# Medworth Energy from Waste Combined Heat and Power Facility

PINS ref. EN010110  
Document Reference Vol.14.4a  
Revision: 1.0  
Deadline: 5  
June 2023

## **Applicant's comments on the Deadline 4 Submissions: Part 1 Statutory Parties**

**MEDWORTH CHP LIMITED**  
**MEDWORTH ENERGY FROM WASTE COMBINED HEAT AND POWER FACILITY**  
**ACCESS AND PUBLIC RIGHTS OF WAY**  
**APFP REGULATIONS: 5(2)(k)**  
**KEY PLAN**

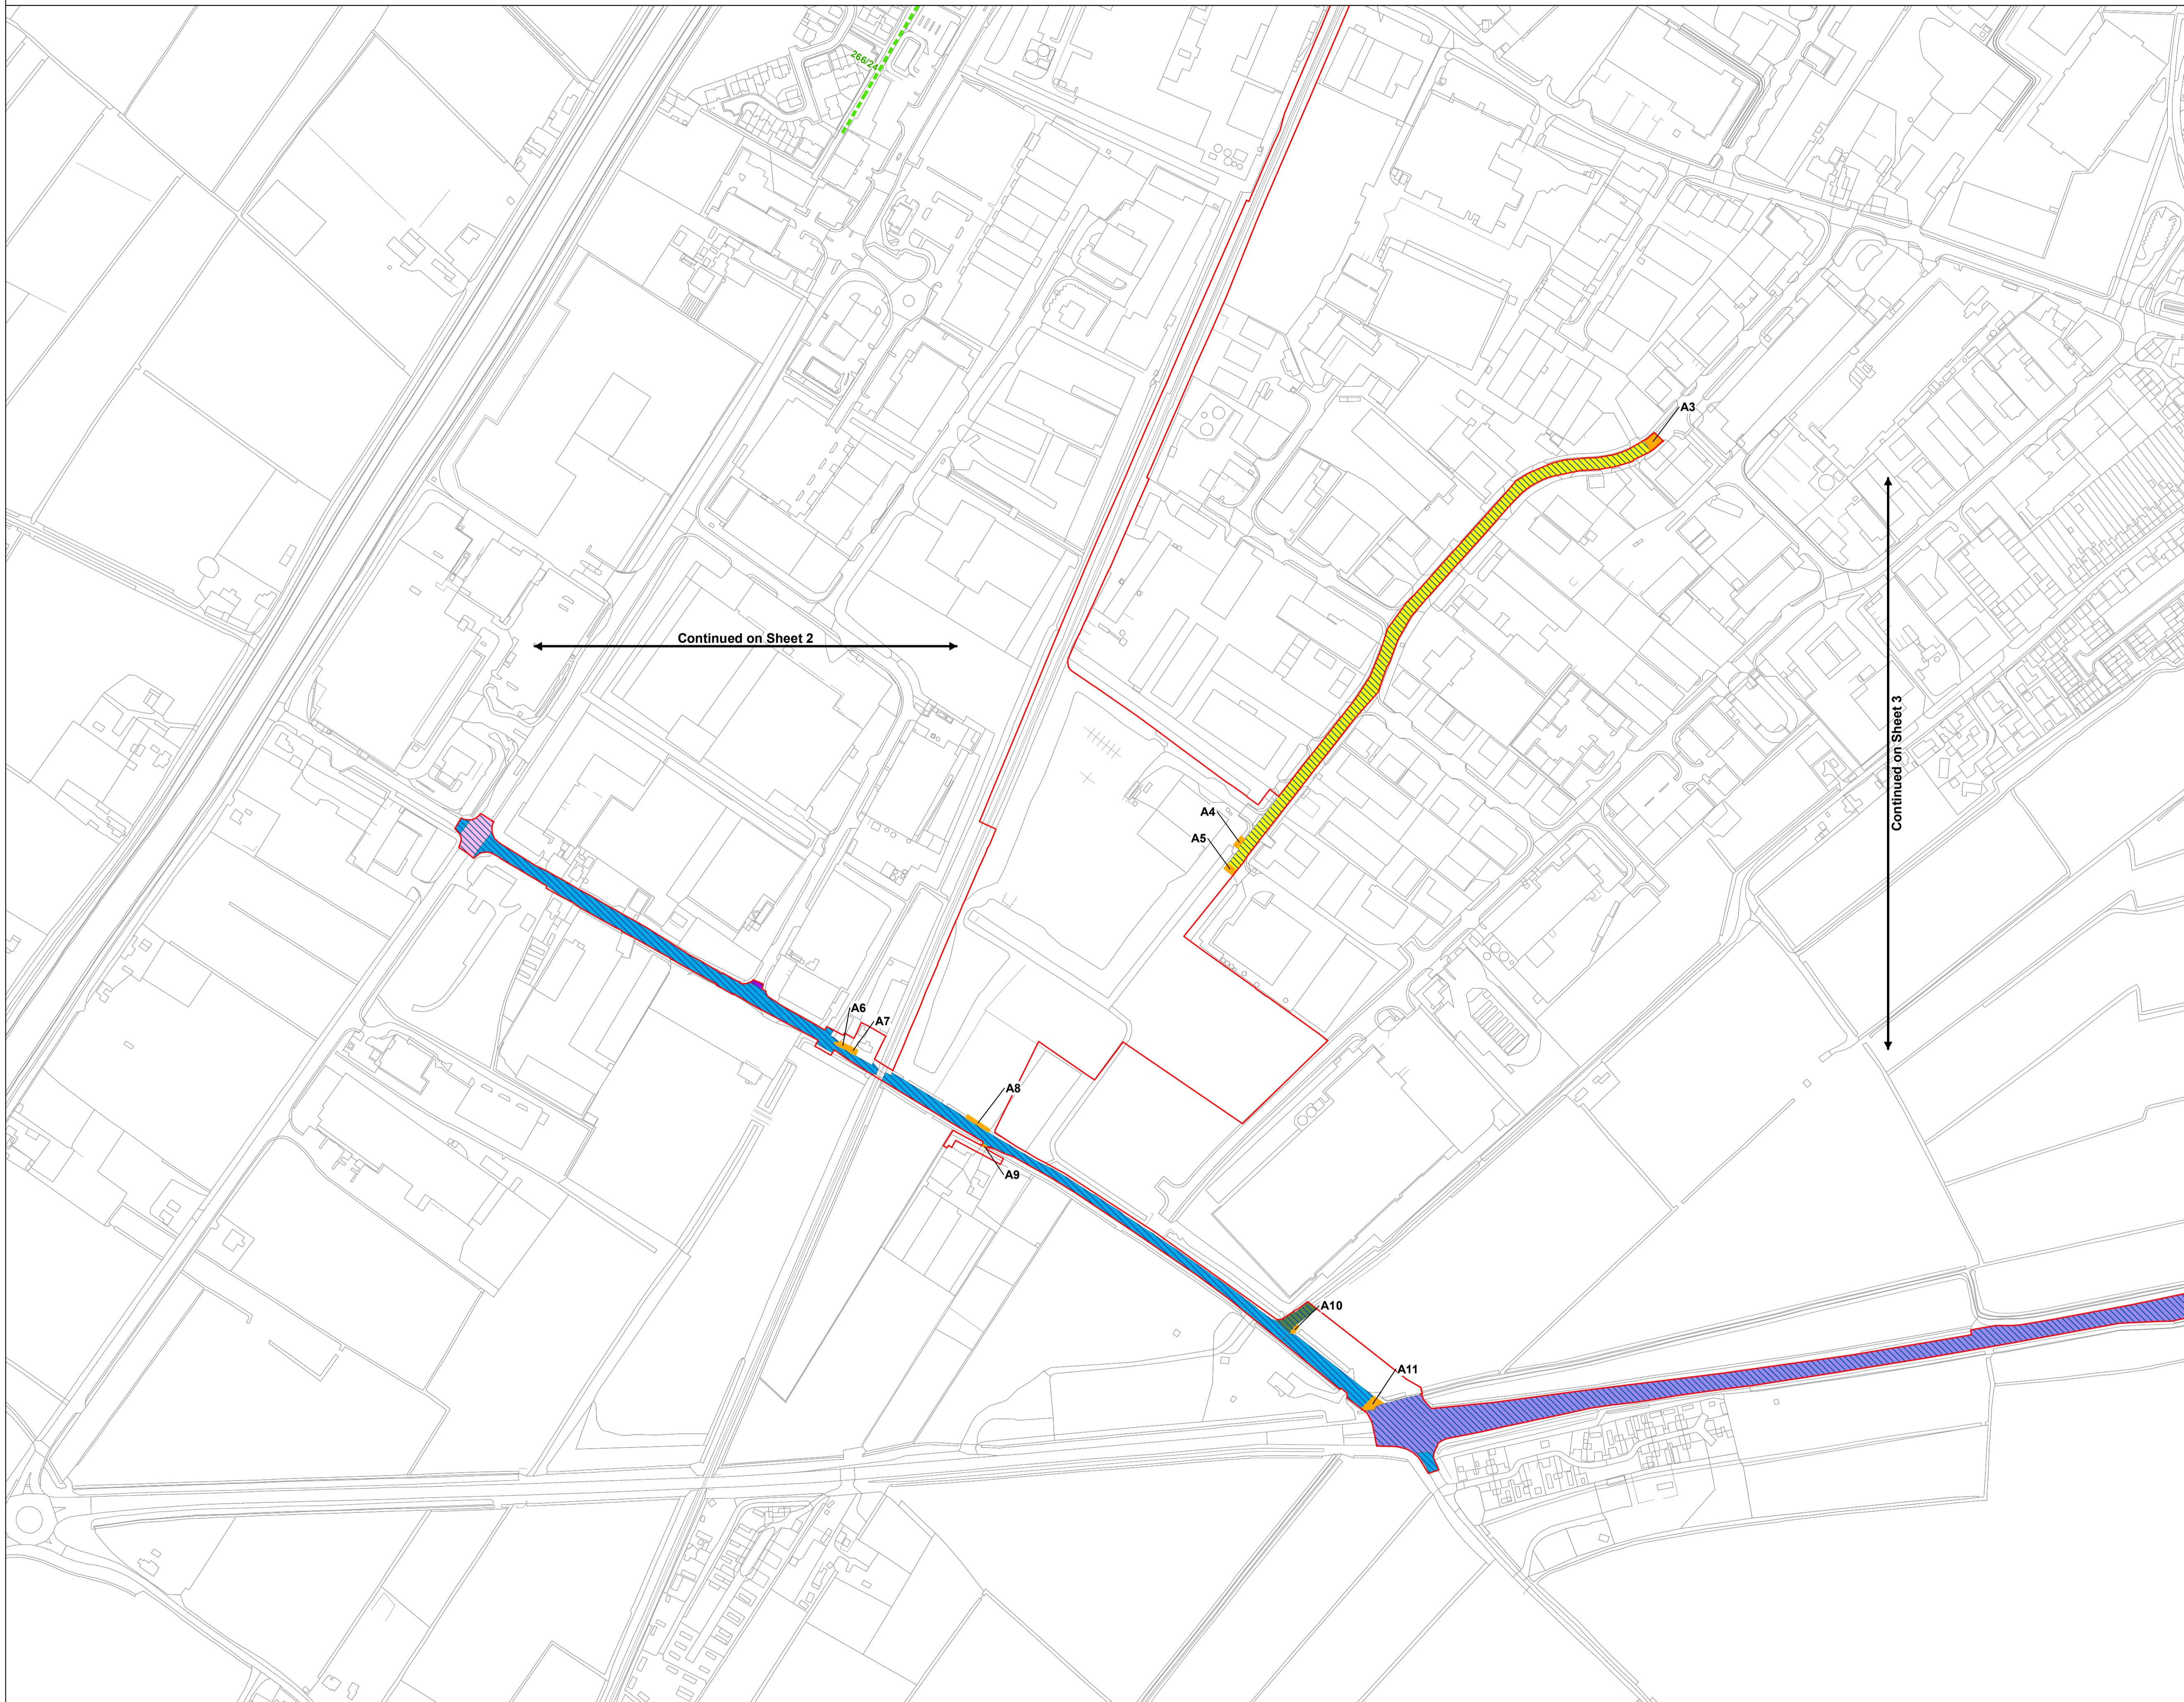
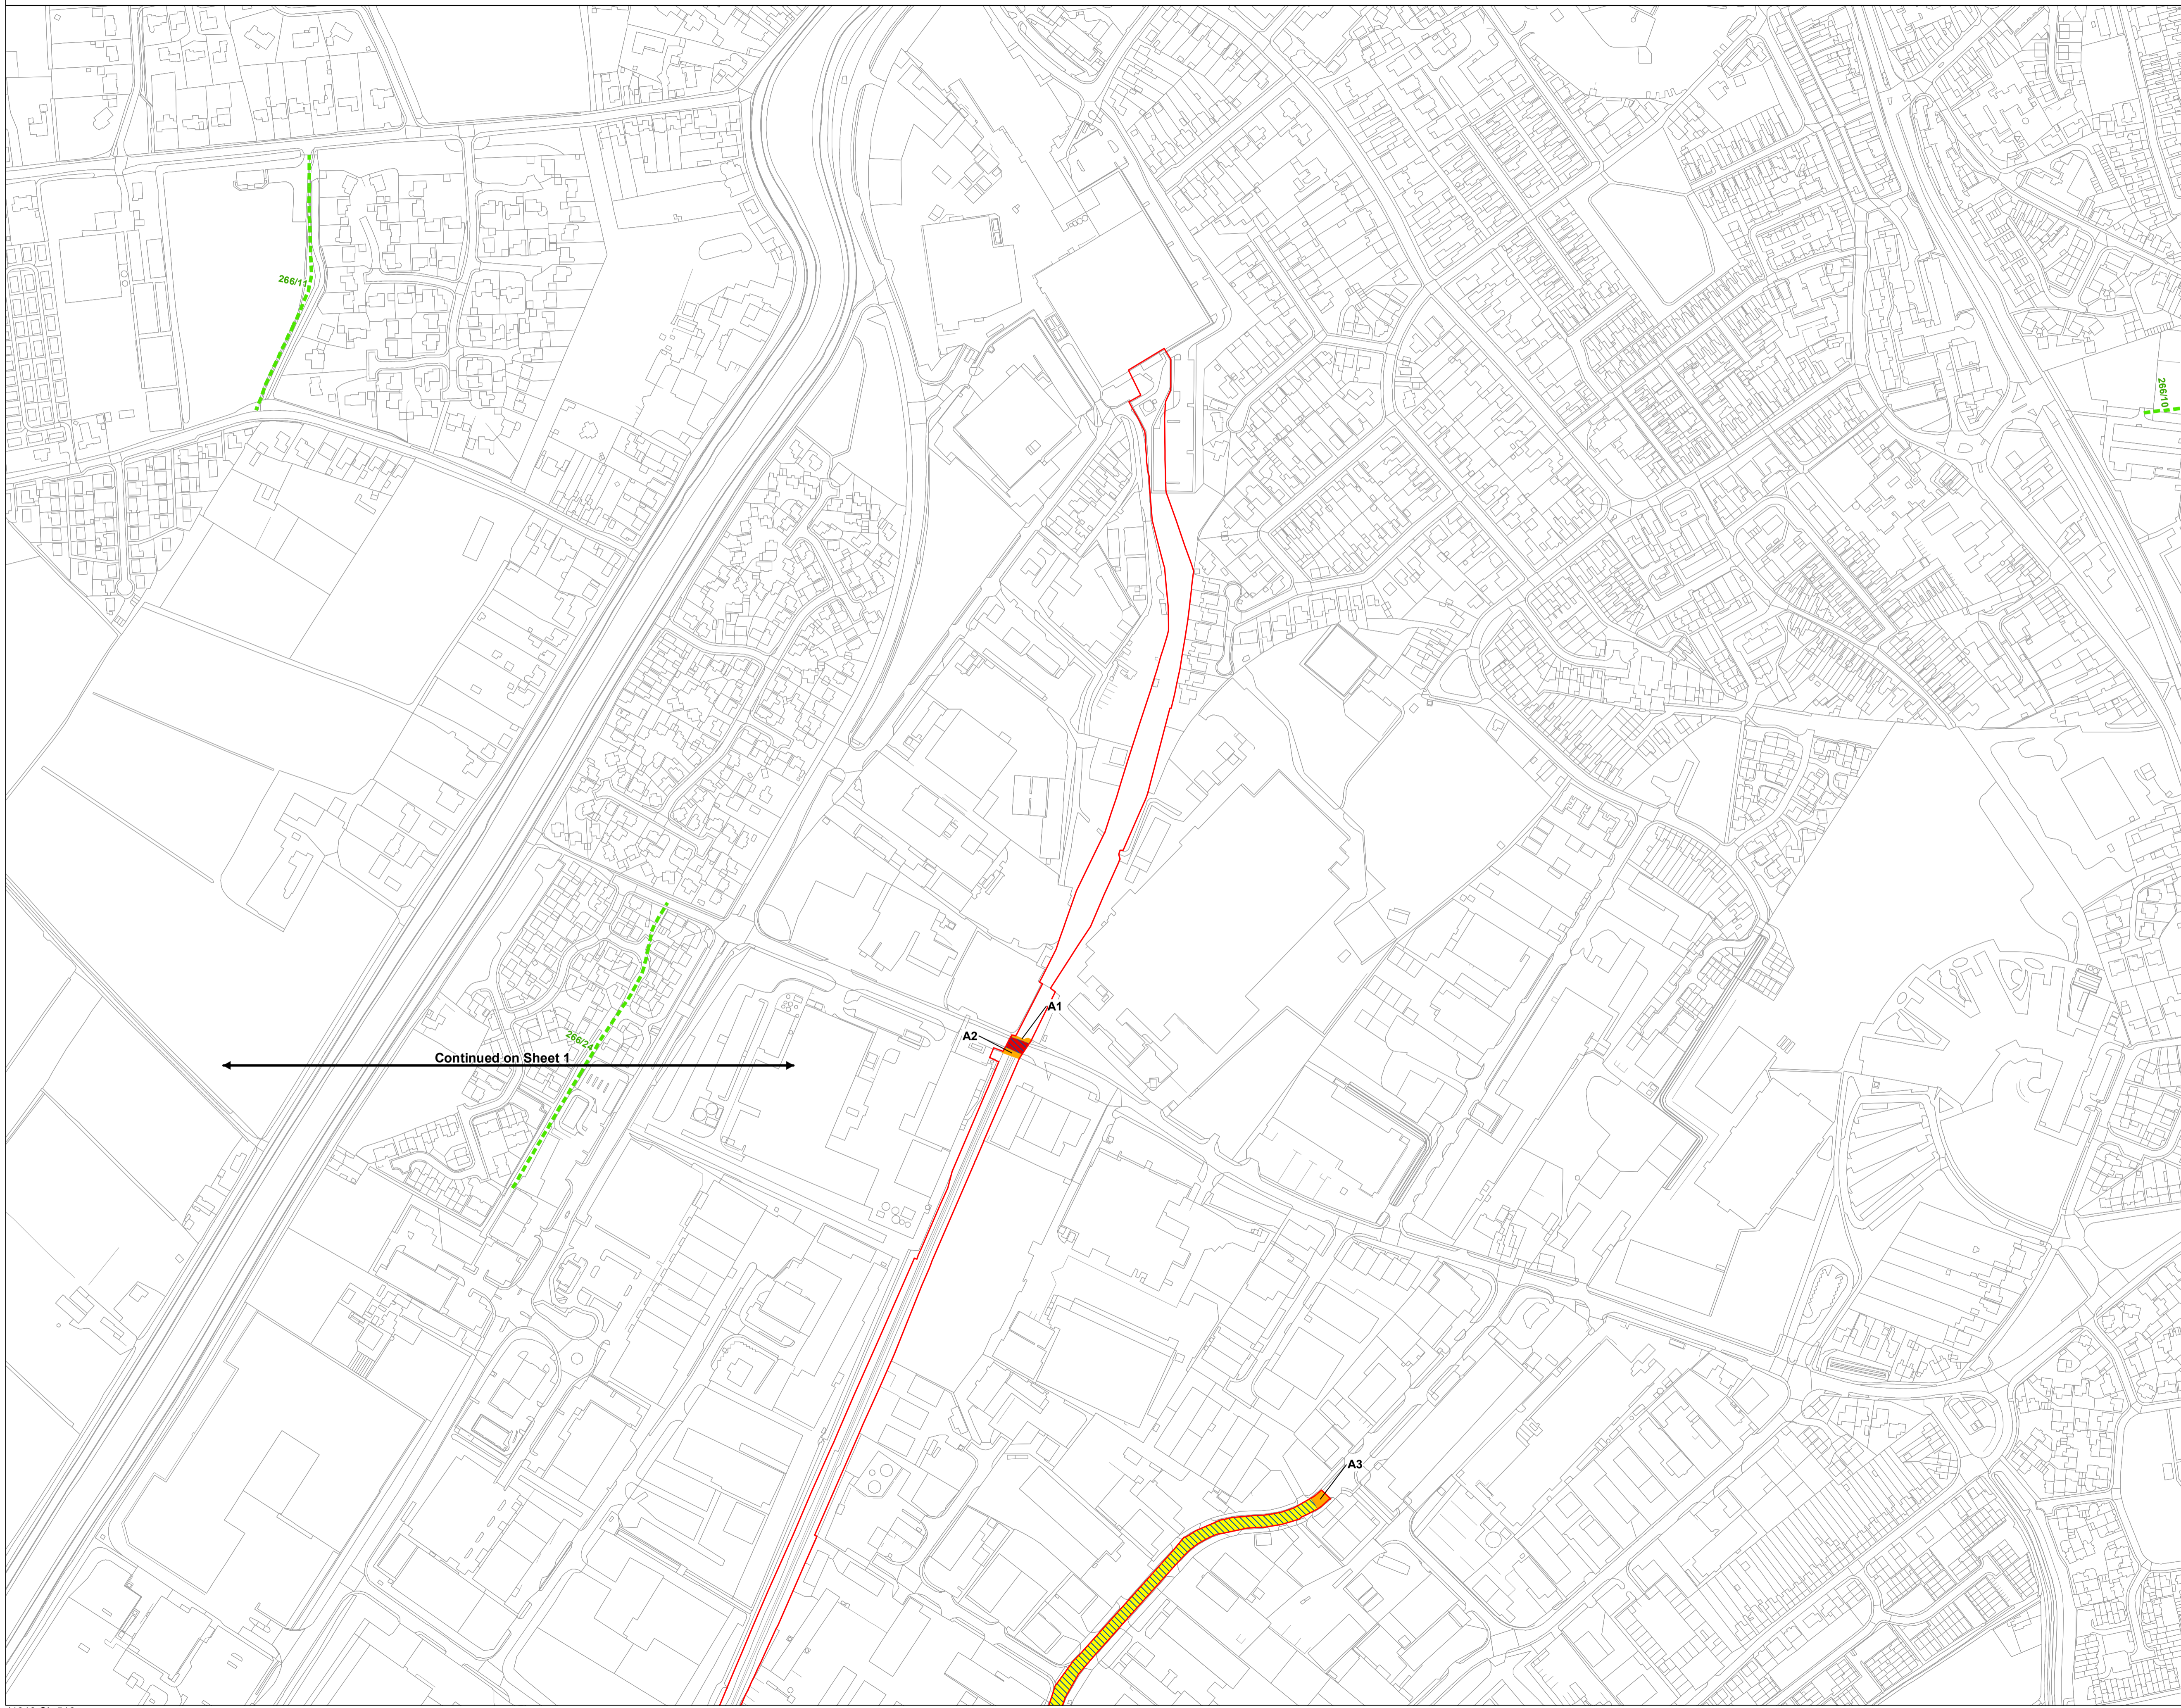
<b>2.4 ACCESS AND RIGHTS OF WAY PLAN (REV 4) [REP3-005]</b>		
Highway boundary – amendment to order limits	CCC was made aware on 16 May 2023 that the Applicant intends to make a request for nonmaterial changes to the Application for Development	Comment noted. Revision 4A of the Access and Rights of Way Plan, showing the proposed change to the Order Limits and access, was submitted to the ExA on 5 June 2023 [AS-021]. As

Topic/Para	Representation	Applicant Comment
	<p>Consent, in order to change the Order Limits at the junctions of New Bridge Lane with (respectively) Cromwell Road and Salters Way. CCC is in discussions with the Applicant about this matter and is considering the impact Page 2 of 19 that changing the Order Limits would have in relation to the extent of the affected highways. The highway boundaries in this location are currently being considered and CCC will continue to engage with the Applicant in respect of this matter.</p>	<p>noted above, the Applicant can confirm that negotiations with CCC are ongoing. The Applicant's change request [AS-028] specifically addressed the point relating to the extent of the highway maintainable at public expense.</p>
Highway boundary – Sheet 2	<p>The highway boundary within the Order Limits on Weasenham Lane is not shown correctly in the vicinity of accesses A1 and A2. The Applicant has been engaging with CCC on this matter and it is anticipated that future iterations of the Plans will be corrected.</p>	<p>The Applicant has engaged with CCC and updated the plan accordingly. The revised plan is submitted at Deadline 5.</p>
